Application by North Somerset District Council for an Order granting Development Consent for the Portishead branch line – MetroWest Phase 1

Issue Specific Hearing 2, Day 1, Monday 11 January 2021

Response to Action Points

Lodway Construction Compound. Work Nos. 17/17A

Project: THE PORTISHEAD BRANCH LINE (METROWEST PHASE 1) ORDER
 Sheets: COMPOUNDS, HAUL ROADS AND ACCESS TO WORKS PLAN SHEET 5
 M5 OVERBRIDGE

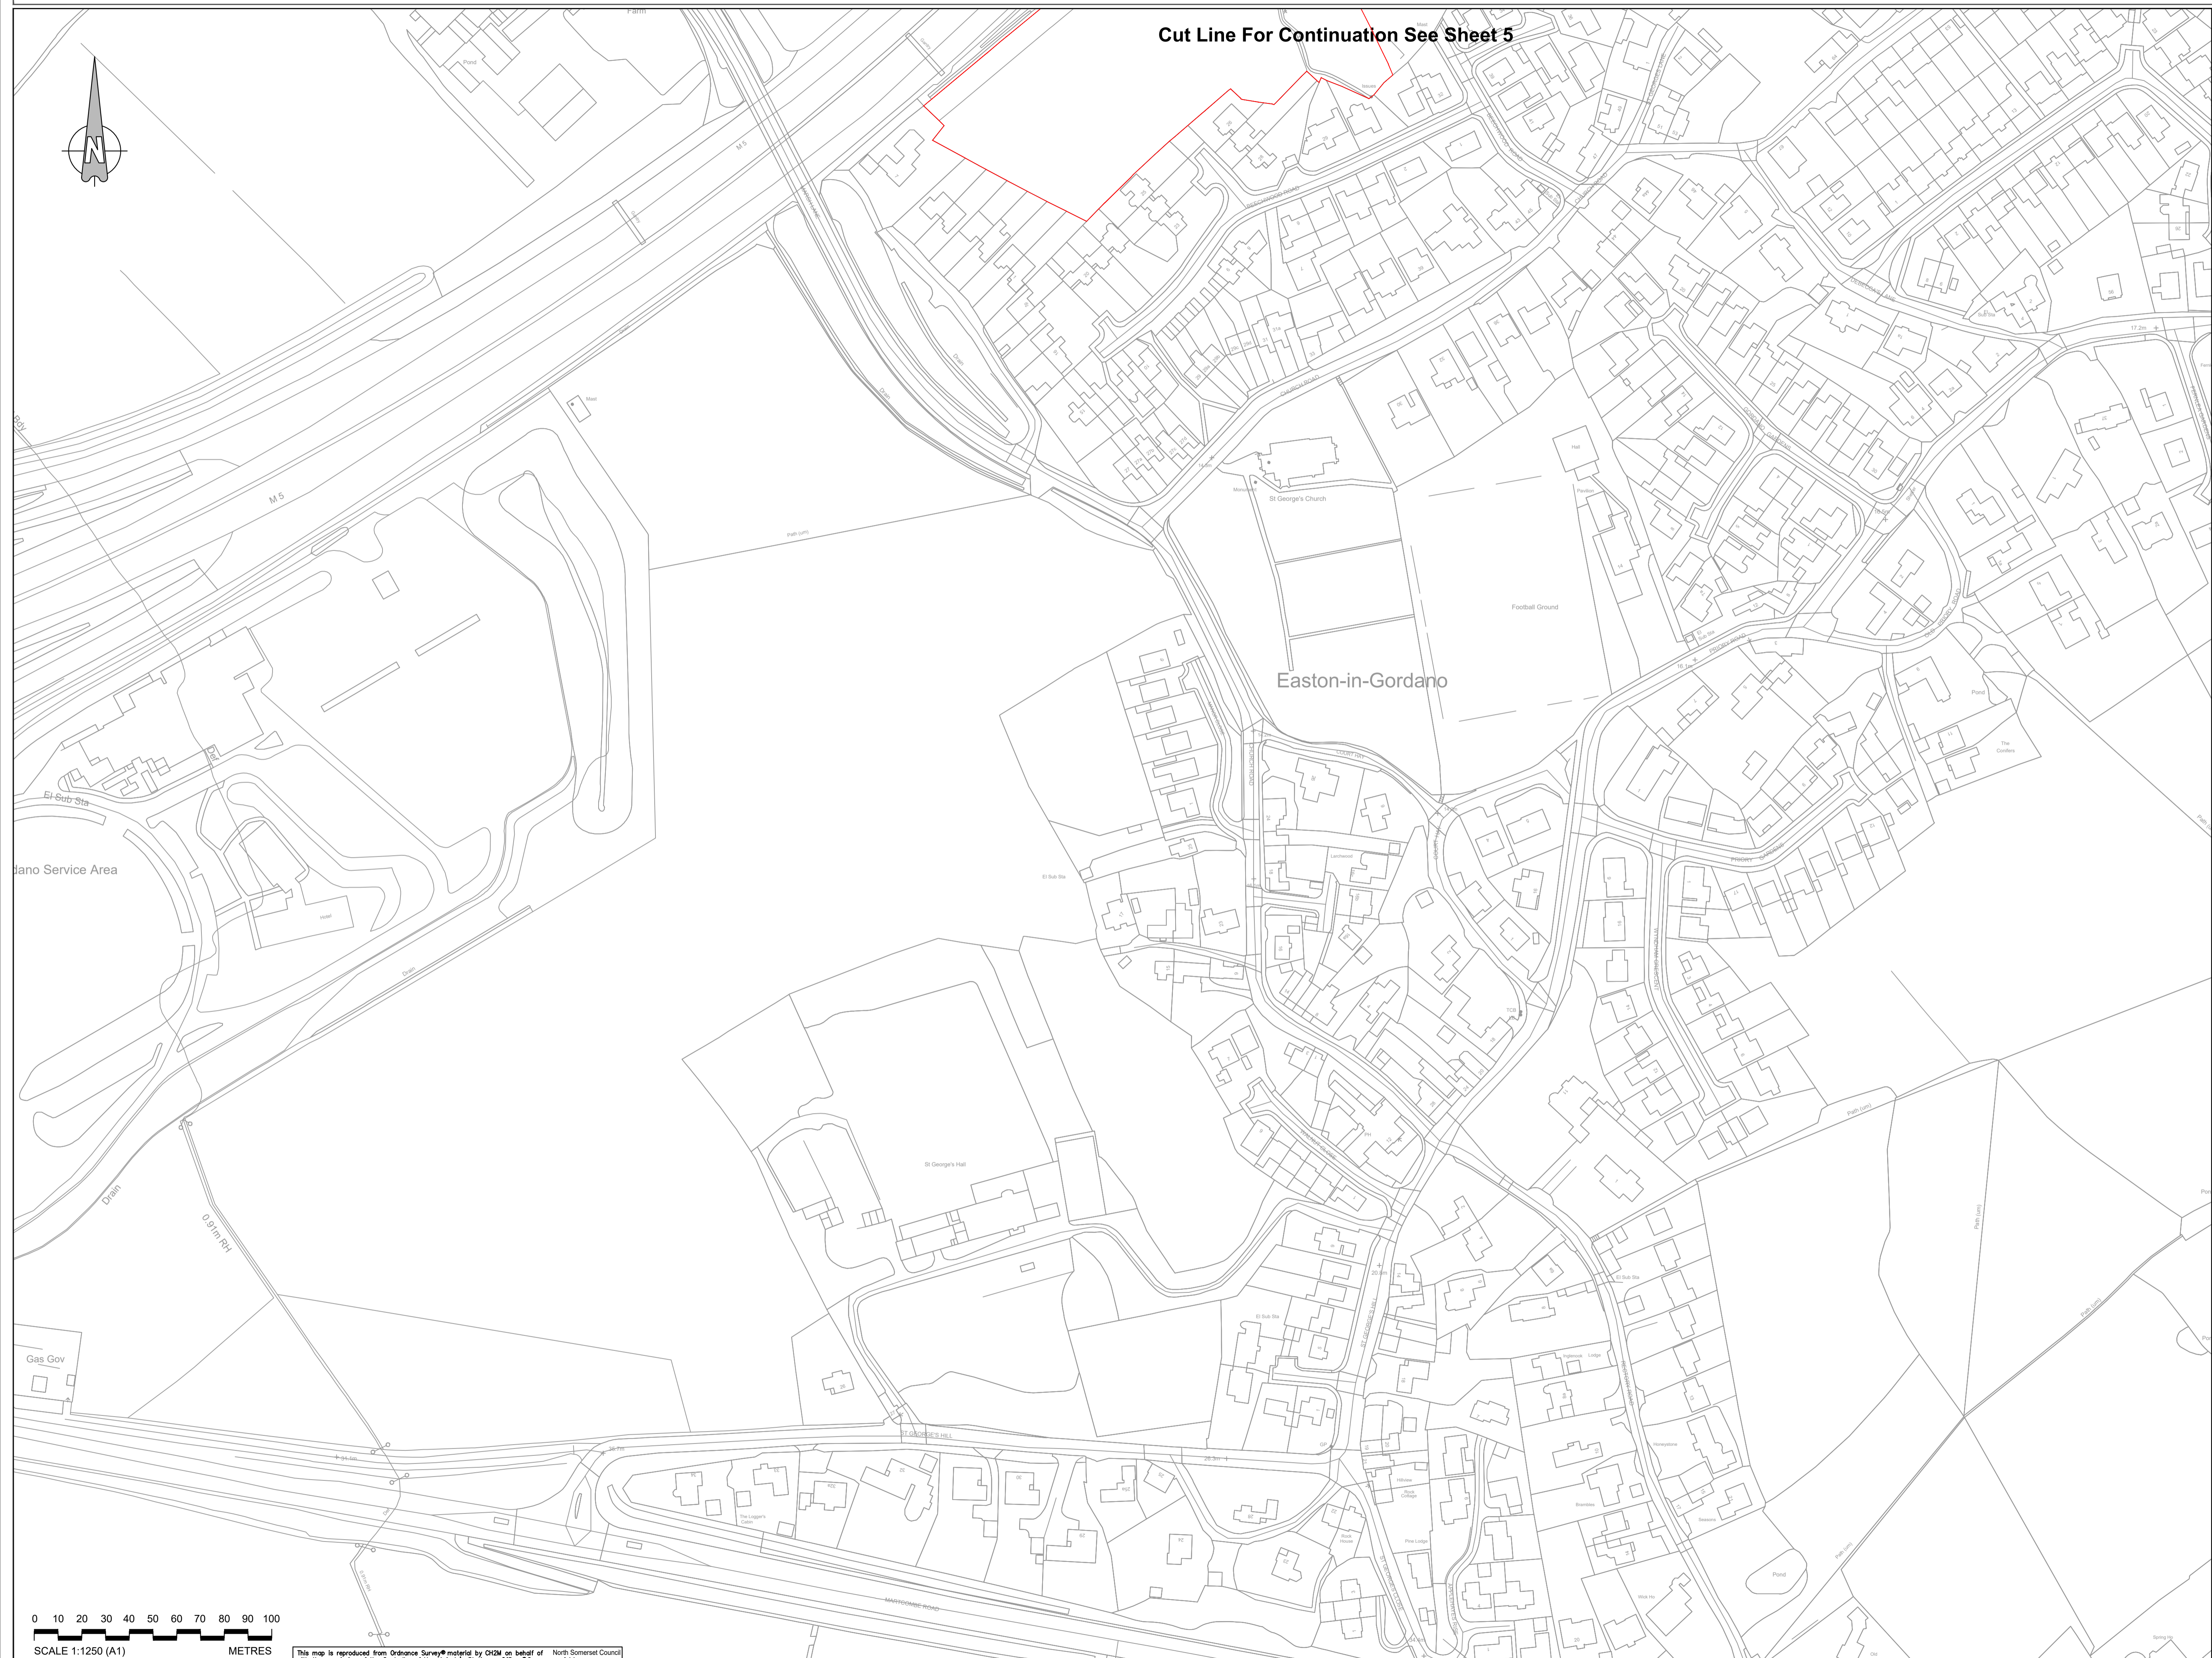
However; on the latest plans (Compounds, Haul Roads and Access to Works Plan, Sheet 5, M5 Overbridge) it shows the Primary Access Point as immediately after exit from M5 tunnel (Pill side).

Please could you confirm which option is correct.
